Harnett County
420 McKinney Pkwy
LILLINGTON, NC 27546
Phone:
Fax:

SUBJECT: SFD2010-0045
SINGLE FAMILY DWELLING

Here are the results of all Inspections located at **102 LINDA LOU LN:**

**Truss Placement Plan**  
**SCALE: 1/4" = 1'-0"**

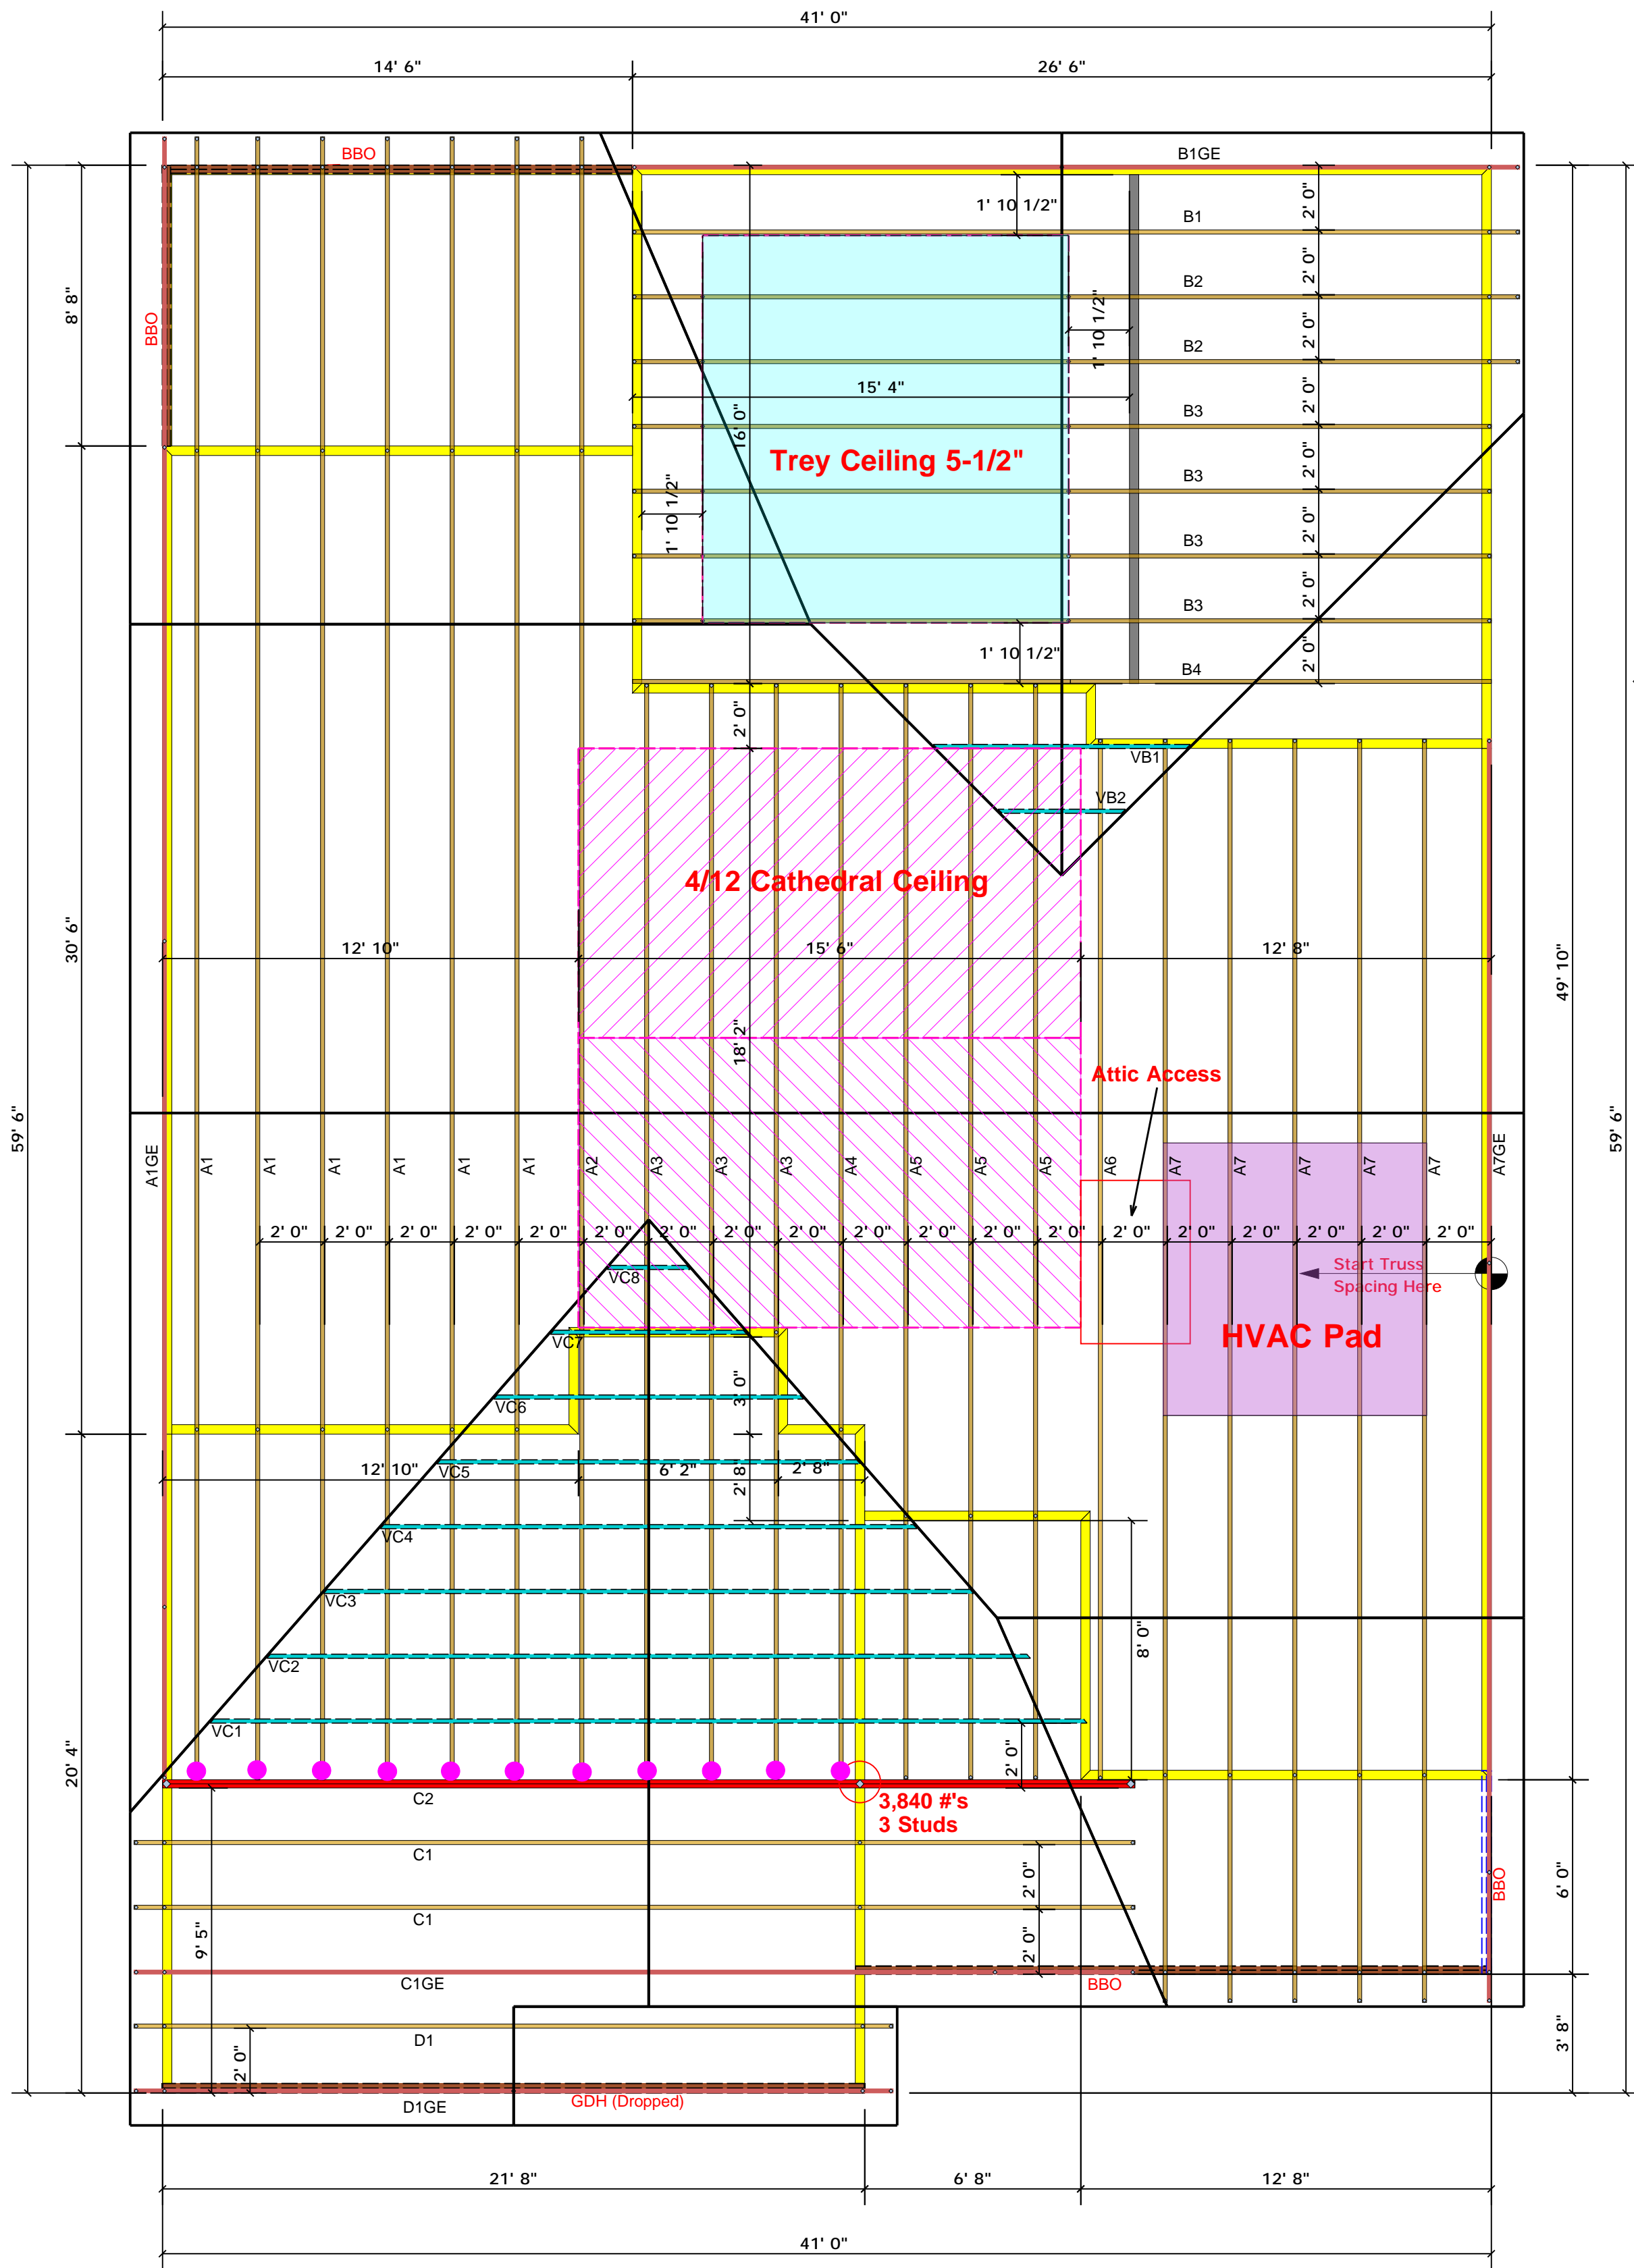
Need engineer repair for damage truss above front bedroom. Gauge for water supply lines in operable no pressure. OK to insulate

1-several roof truss not seated in hangar attached to two ply girder in garage. 2-missing anchor bolt right rear corner of garage. 3-Front and rear porch framing and beams covered with siding please remove for inspection. 4-Front porch backfill requires compaction test. 5-A7 truss break (repaired.) engineering letter and file. 6-Master bath tub missing. 7-VB1 And VB2 truss missing. Area stick framed. 8-gas test down. 9-Seal floor under master shower pan around drain. 10-attach porch post per plan. OK to insulate
